CITY OF PORTLAND BUILDING PERMIT

Located At 254 COMMERCIAL ST
Merrill's Wharf - Pierce Atwood Law Offices

Job ID: 2011-05-1135-FAFS

Installation of a Master box fire alarm system

FIRE ALARM
 RISER DIAGRAMS
E3.2
 09.23.2010

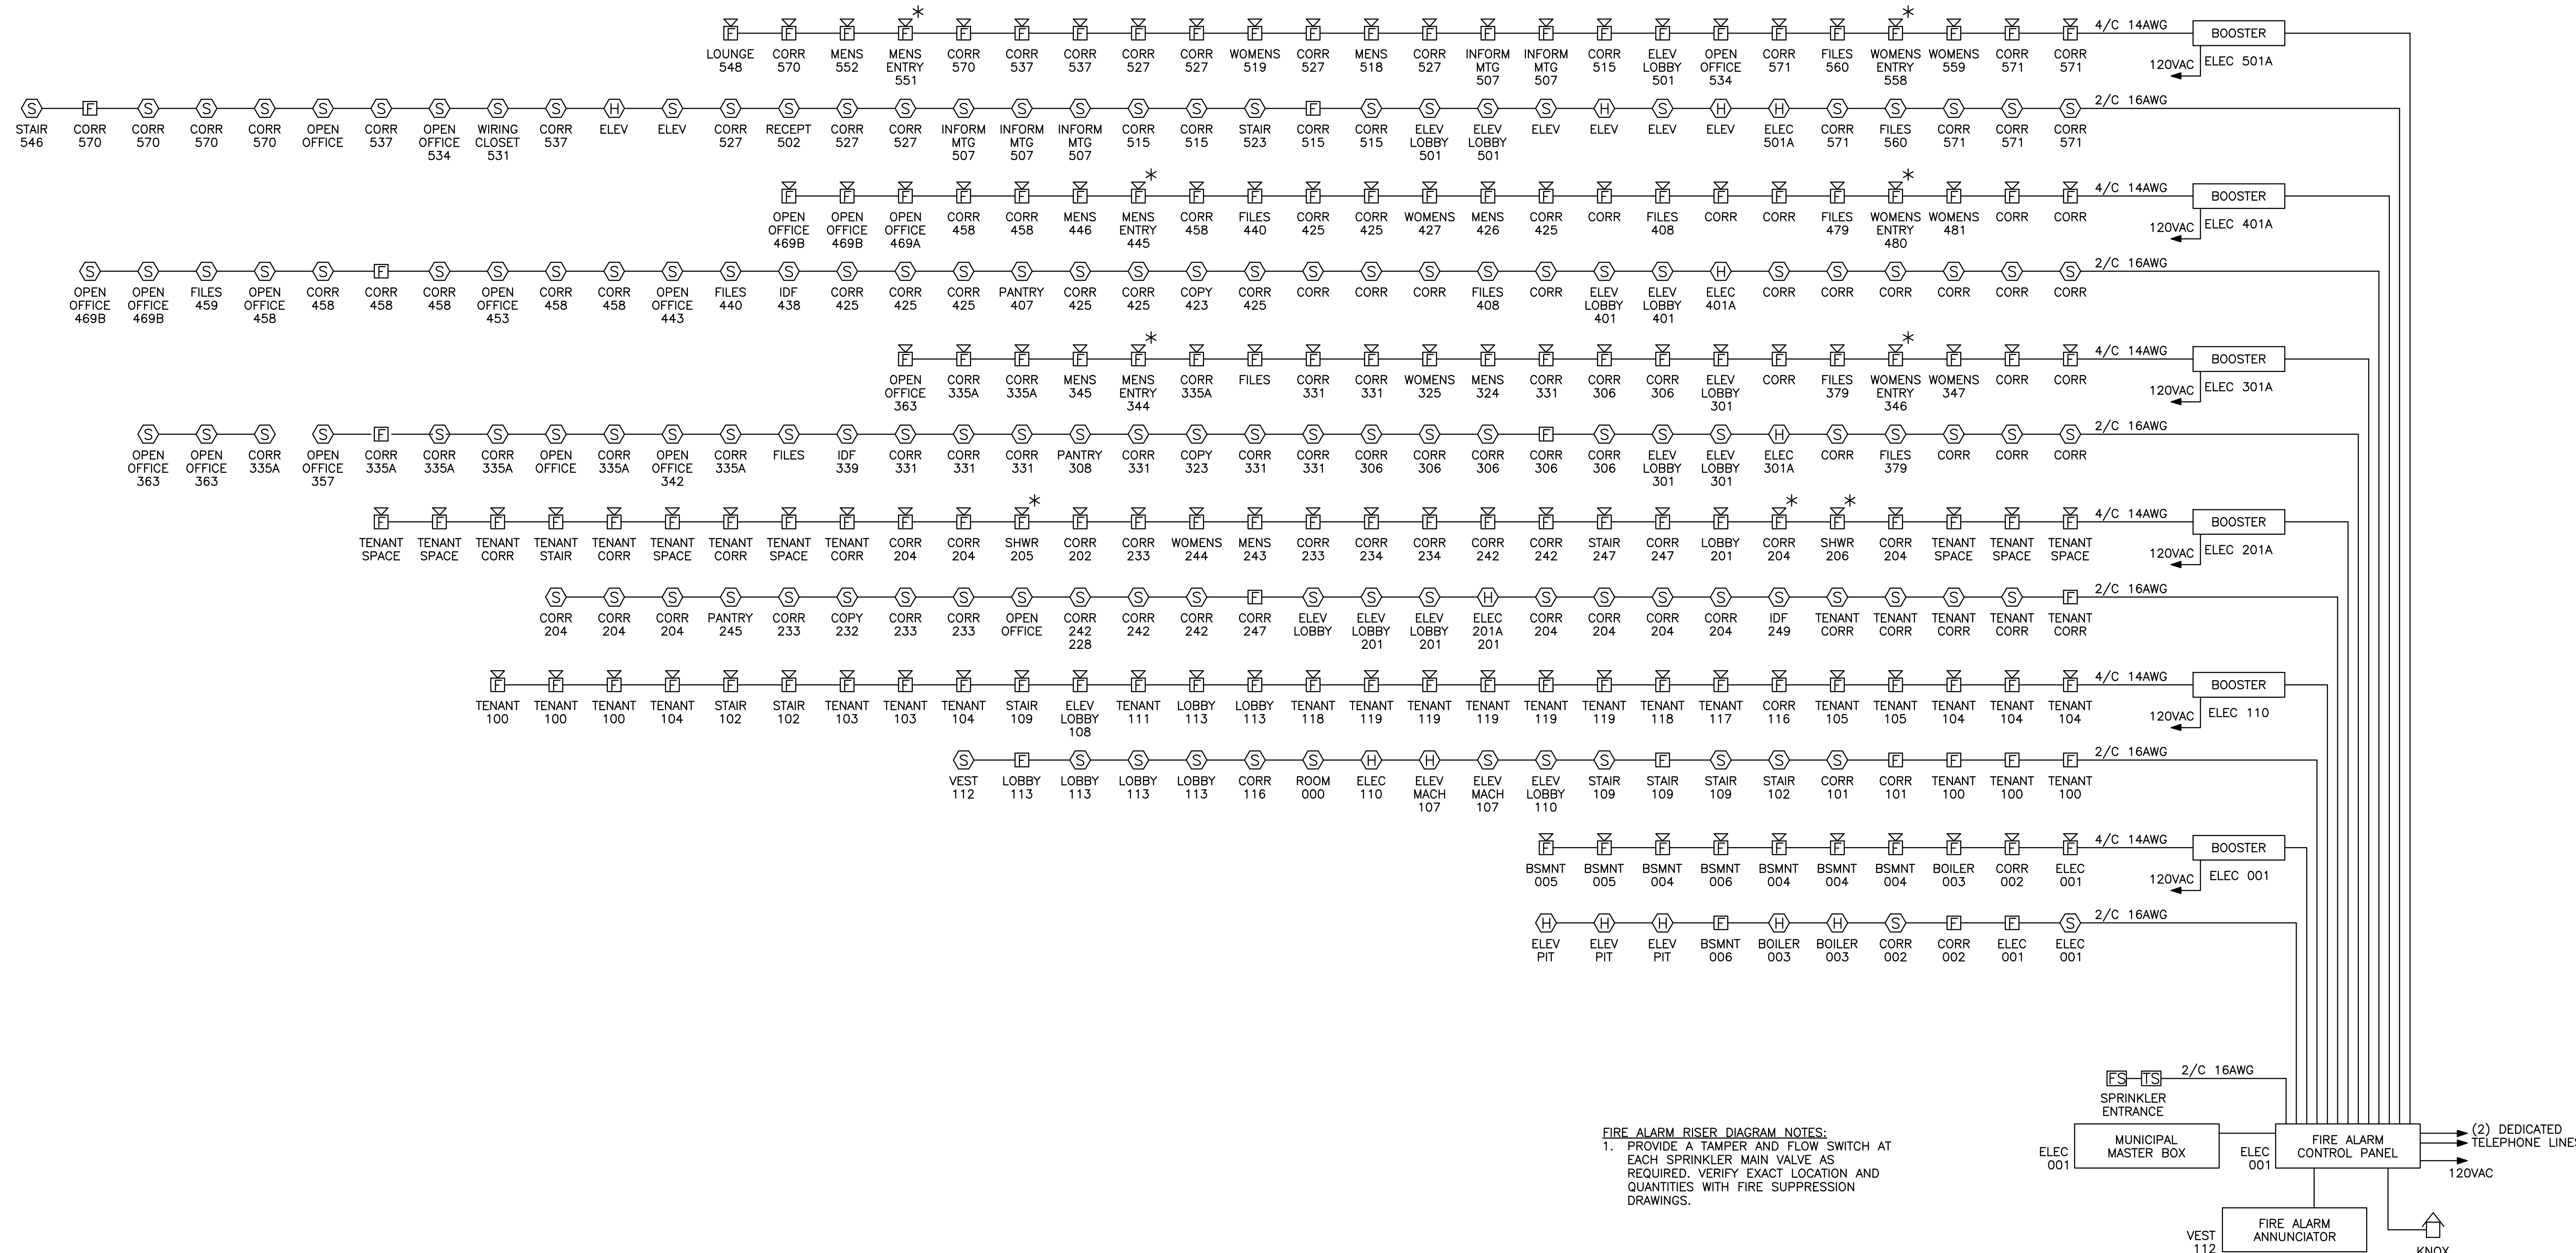
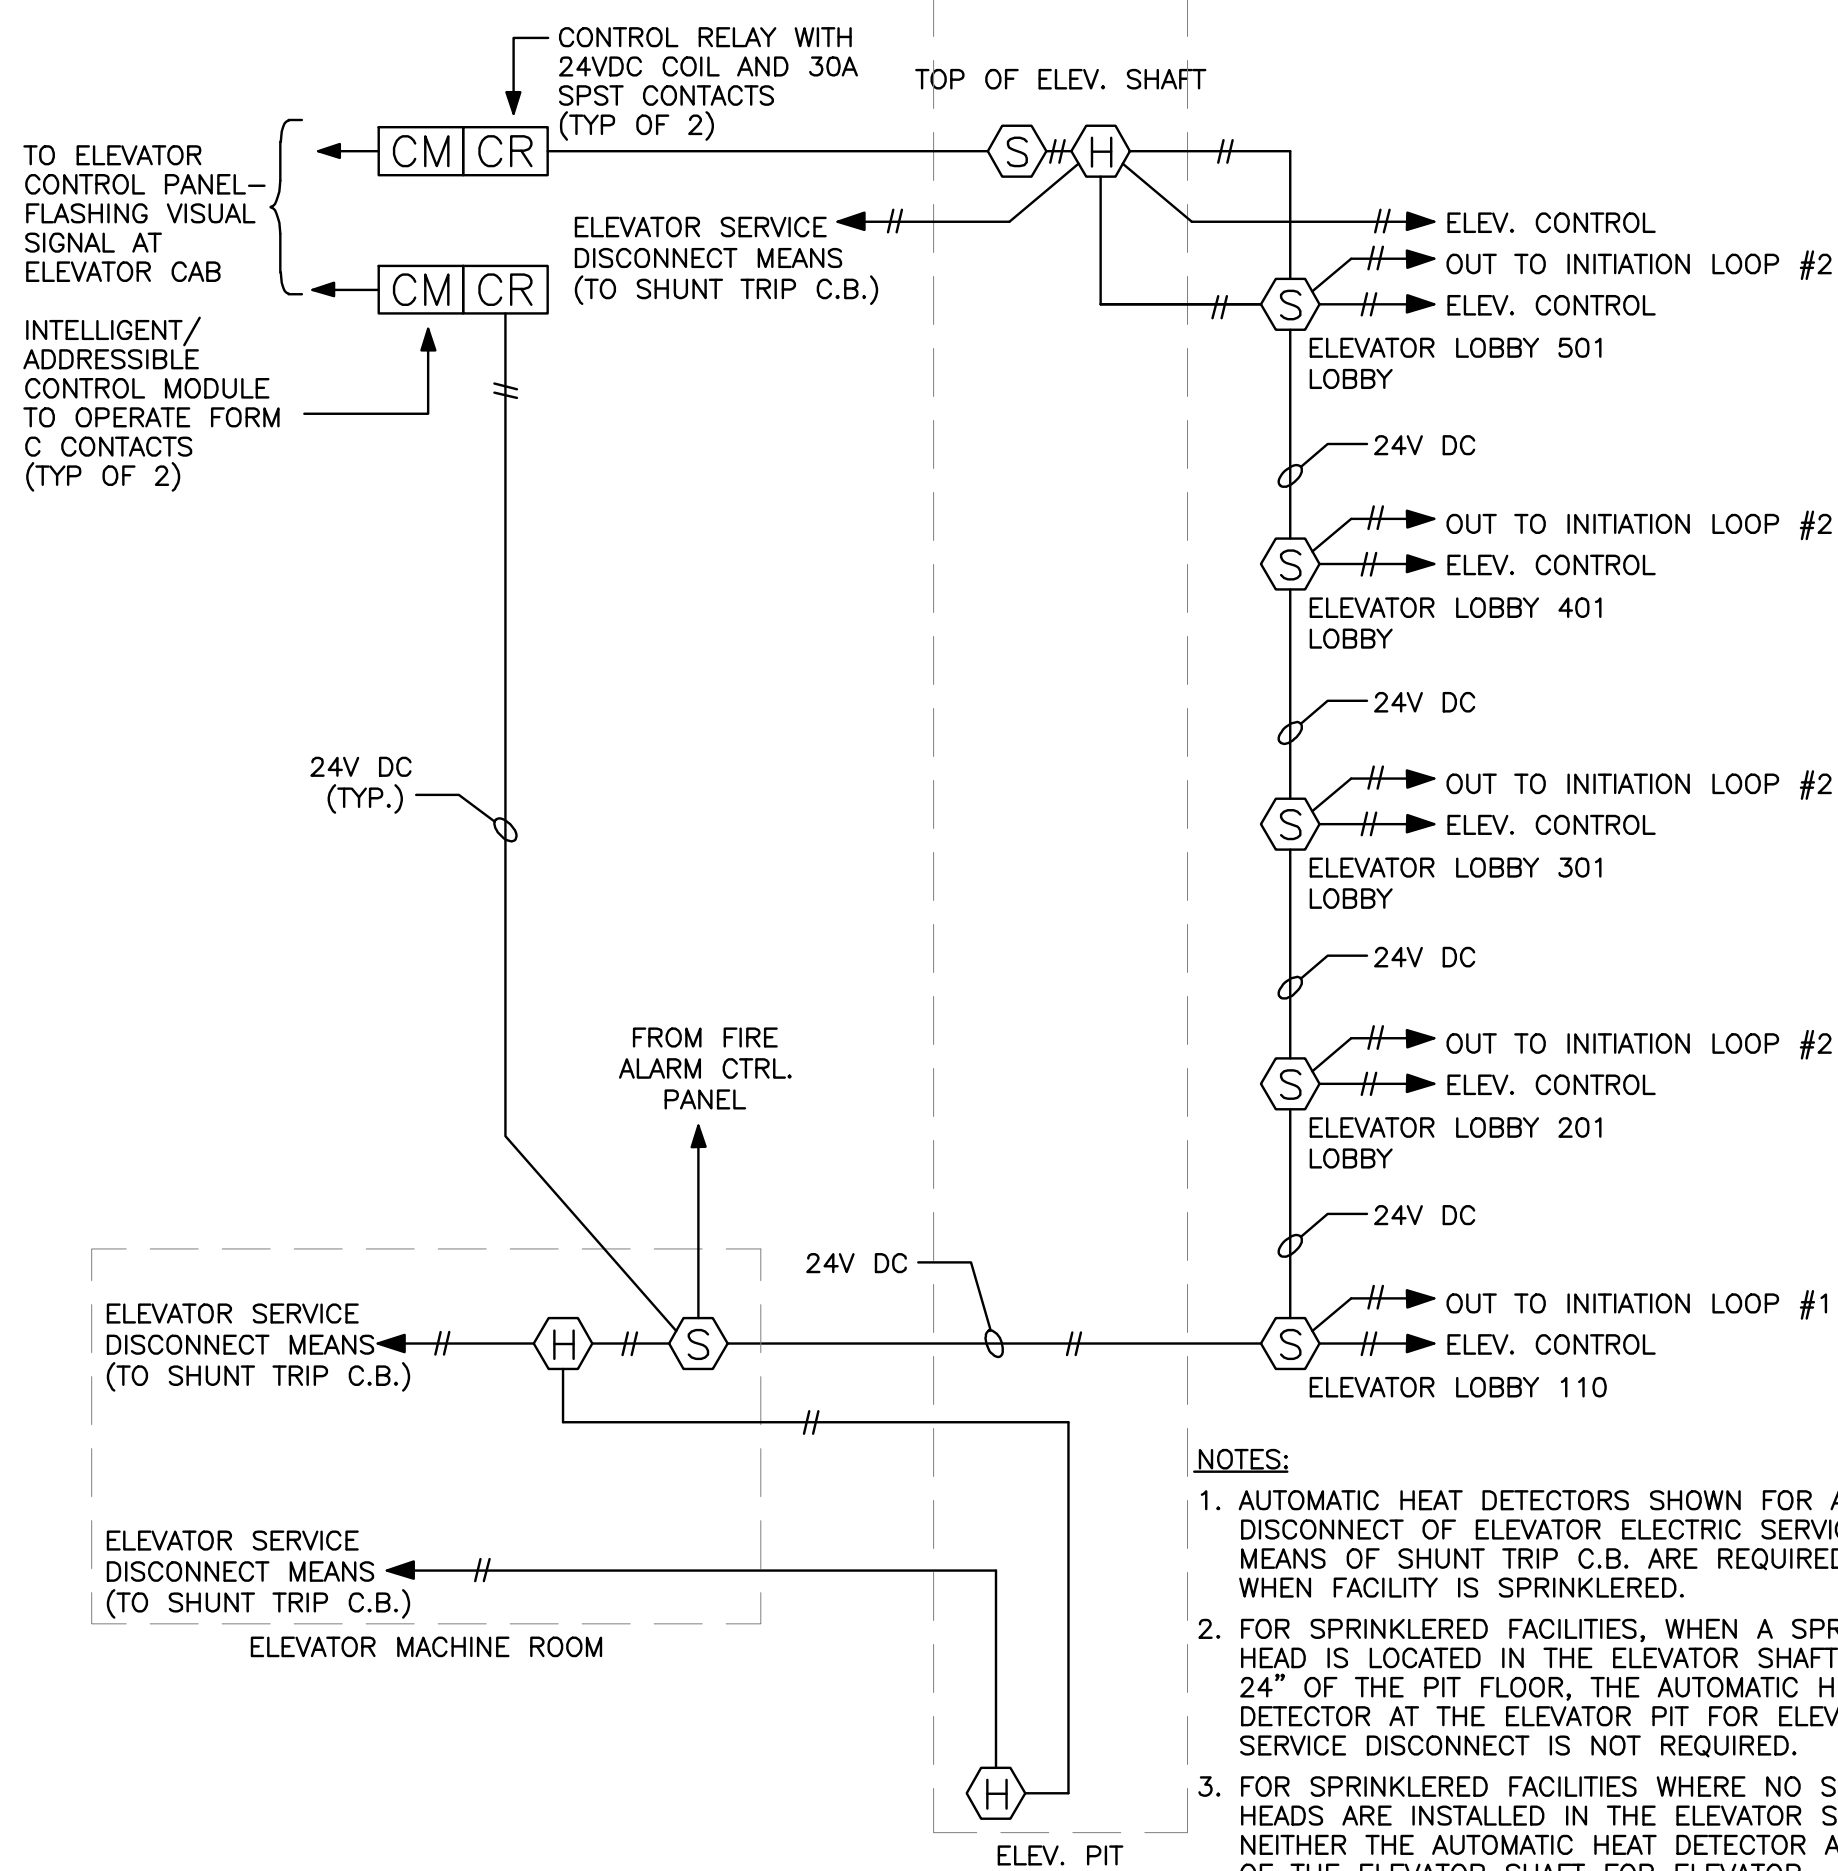
Duct detection shall be supervisory and not trip the evacuation signals or master box.

1. Complete smoke detection is not required for this building by the life safety and fire codes. Duct detection (supervisors), elevator detection and the detection for the fire alarm system itself is. Also the plans call for 2 smokes in front of every elevator lobby but as long as there is one within 21' of the centerline of the elevator door its all set. All of the extra detectors are allowed but not required.
2. The pull stations and sprinkler water flow and supervision by floor are required.
3. The plan doesn't show a pull station from the basement corridor 002 to the exit stair.
4. I need the master box approval form for the system.
